**CITY OF ALBUQUERQUE
PLANNING DEPARTMENT
October 25, 2004
DRB Comments**

PROJECT # 1003689

RE: Lots 1-3, Block 13, Perea Addition/minor plat

PLAT OF TRACT A, BLOCK 13  
 PREVIOUS DESCRIPTION LOTS 1,2 and 3  
 BLOCK NO. 13

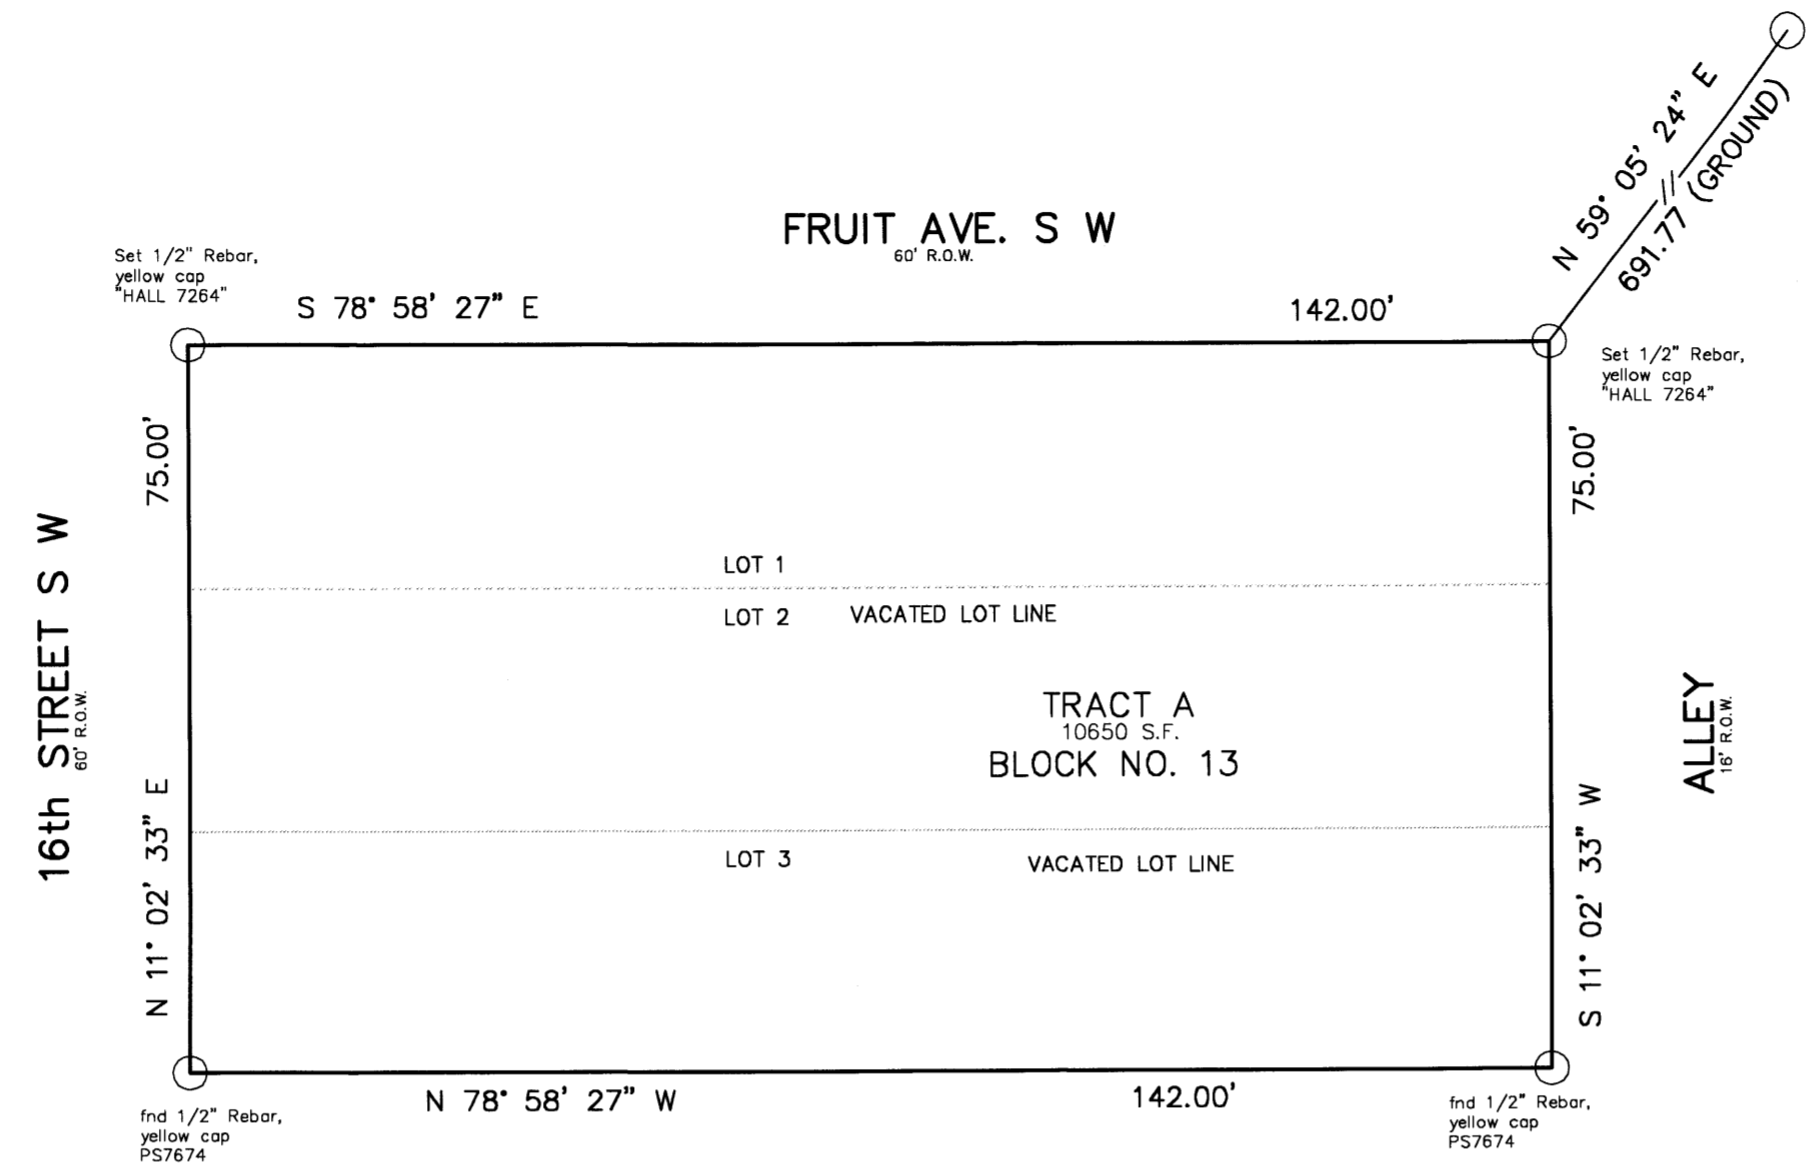
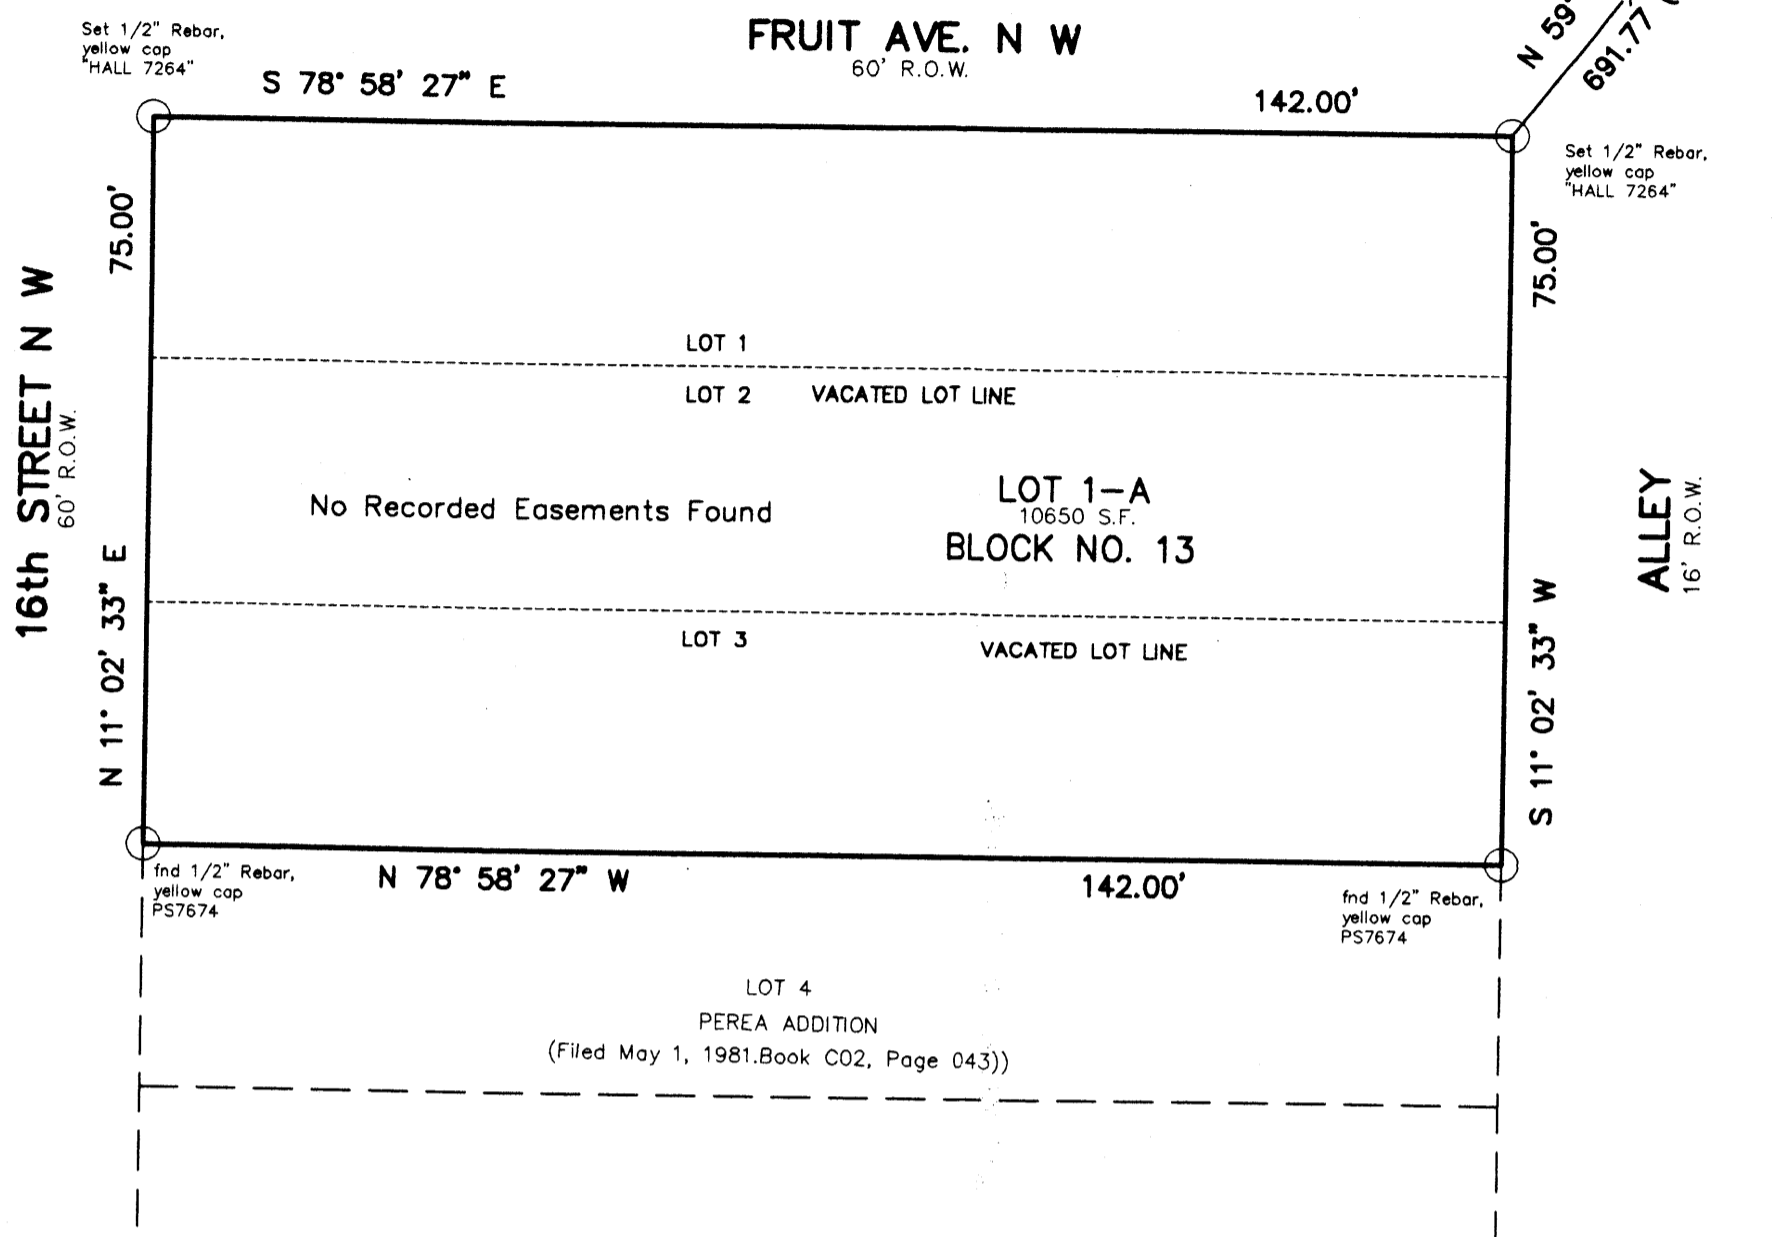
1. "Said owner warrants that he holds complete & indefeasible title in fee simple to the land subdivided"....Add this language above the owner's signature.
2. AGIS dxf is approved.
3. Planning will file the plat. See Claire for details.
